Householder Proforma

Application Ref: 2021/0889
Address: 14 Lund Crescent, Lundwood, Barnsley, S71 5LQ
Neighbour Representations: No
Consultations No
Property Description: the property is located in a purely residential area of similar styled dwellings. The property in question is located in a unique position within its attached neighbour. The attached property is located up to the back edge of the pavement at a bend in the road with the properties to the east of the application dwelling being located at 90 degrees to it.
The two storey, pitched roof dwelling is constructed from buff brick with brown concrete roof tiles.
Proposed Extension: erection of a first floor side extension above existing single storey side extension
UDP Designation: Housing Policy Area
Local Plan Designation: Urban Fabric
Conservation Area: No
Relevant History: N/A
Acceptable in Principle: Yes

DRAWING STAGE:
PLANNING
DRAWING TITLE:
PROPOSED ELEVATIONS

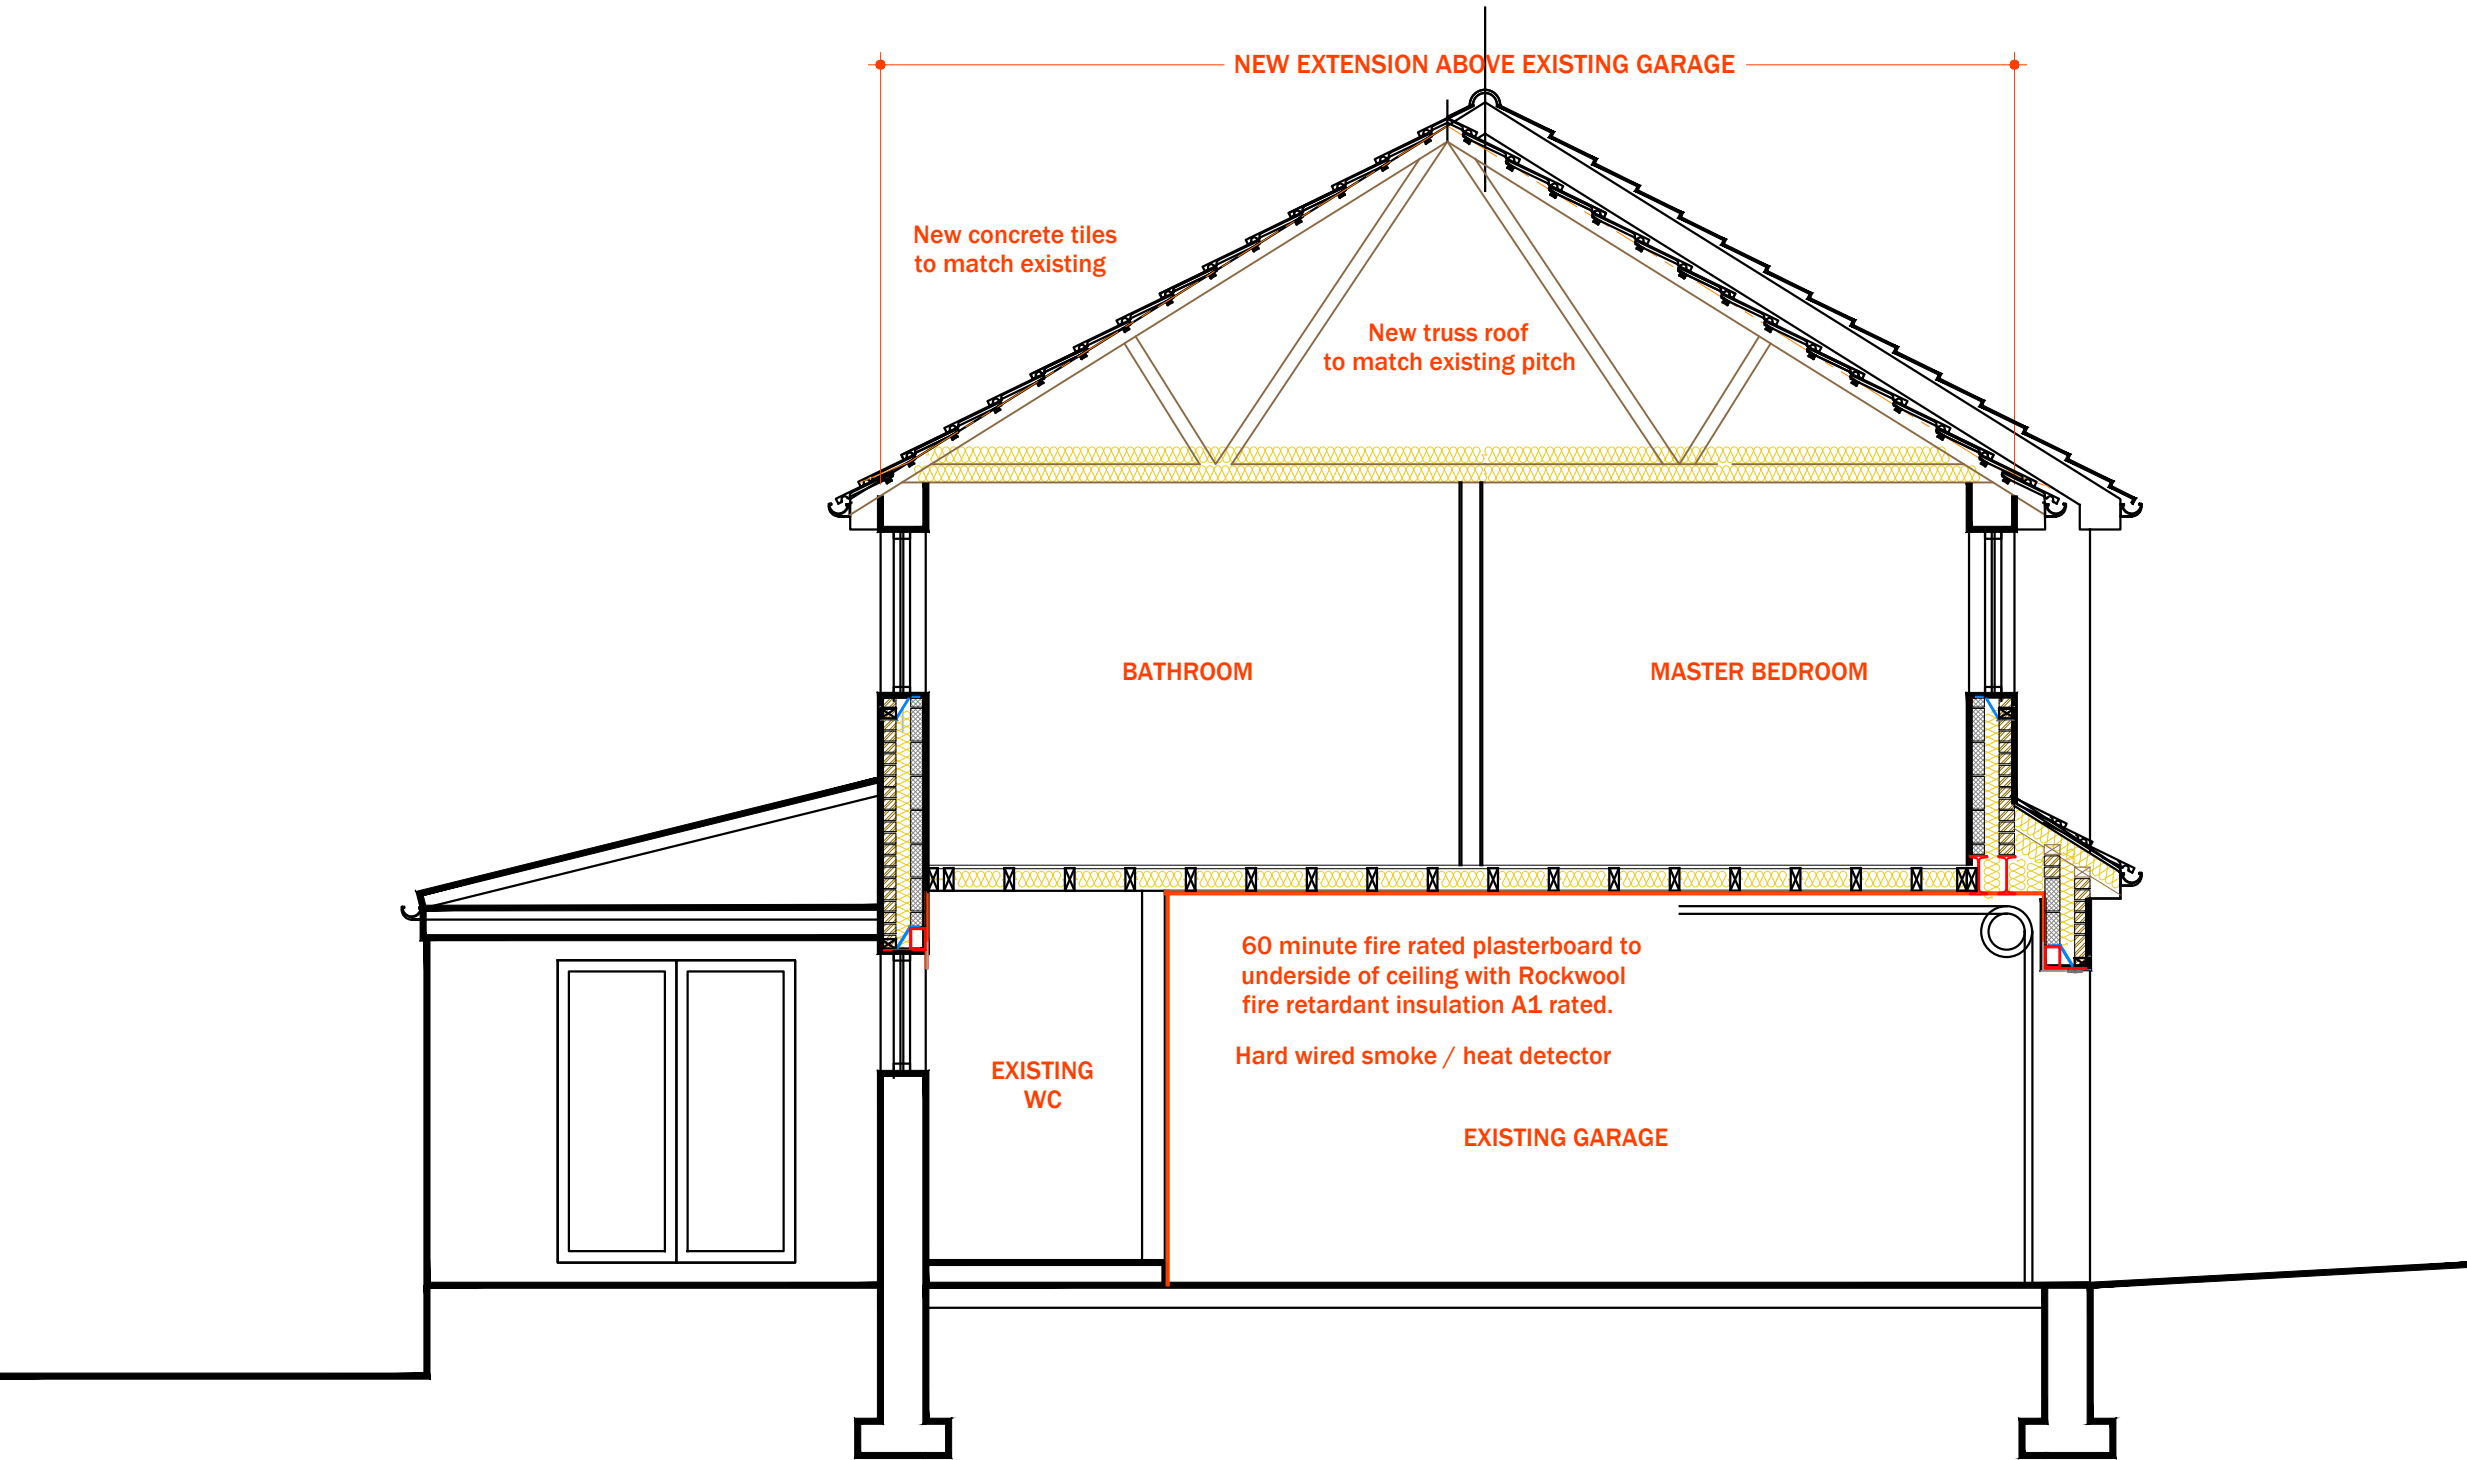
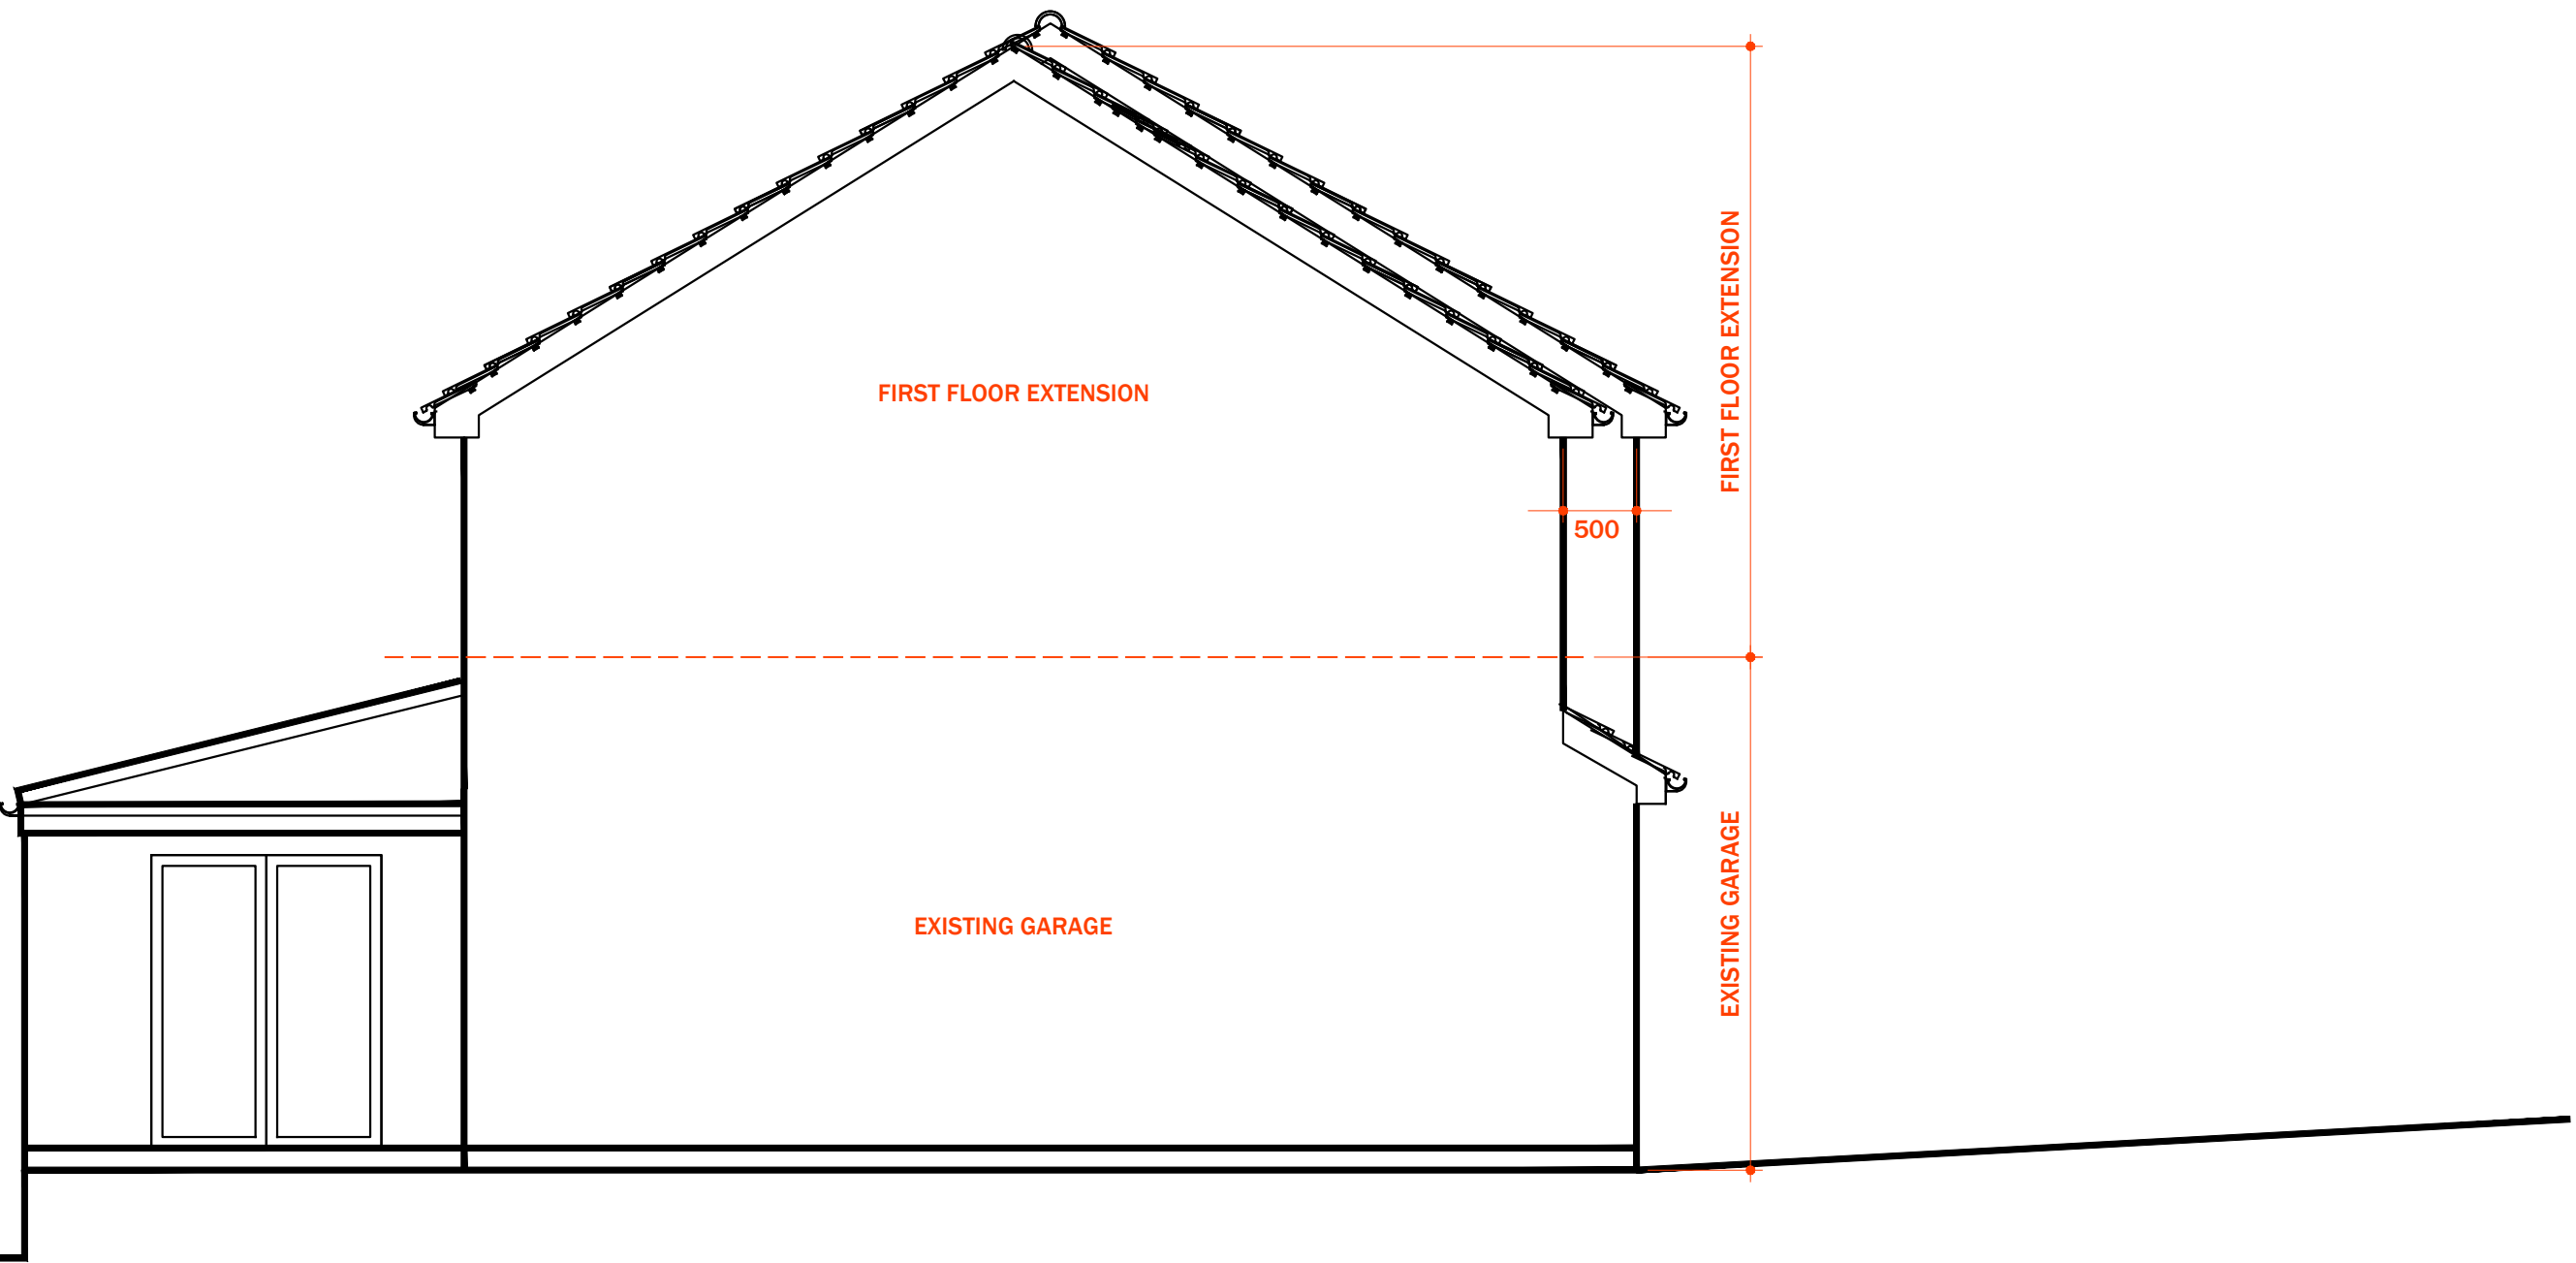
The proposal has been amended during the application process which includes the set back at first floor level.

Yes / No (include comment if required)
Single Storey	
1. set back	
Two Storey / First Floor	
2. set back / set down (500mm minimum)	Yes: 500mm
3. less than 2/3 the width of the original dwelling	No. proposed dwelling 5.5m - proposed first floor side extension 4.4m. Under SPD 2/3 width of dwelling is allowed, in this case 3.6m. Given that the extension is located above an existing single storey side extension the width cannot be reduced to comply with the policy without looking contrived. The pair of dwellings are located in isolation within the street scene, with an extensive gap between the side elevation of the dwelling as extended and the rear elevation of the neighbouring property and the original dwelling remaining the dominant feature with the inclusion of the set back of 500mm at first floor level. Therefore the increase of 0.8m above the allowances set out in the SPD is considered acceptable in this instance.

4. roof design corresponds to existing	Yes
5. windows / doors of a similar design / proportion	Yes
6. habitable room windows on the side elevation	no
7. materials to match	yes
8. neighbouring property extended to side or windows?	Properties to the side have a rear elevation facing the proposed extension approximately 18m well in excess of 12m set out in the SPD between habitable room windows and blank gable walls
9. Any change to parking or access?	no
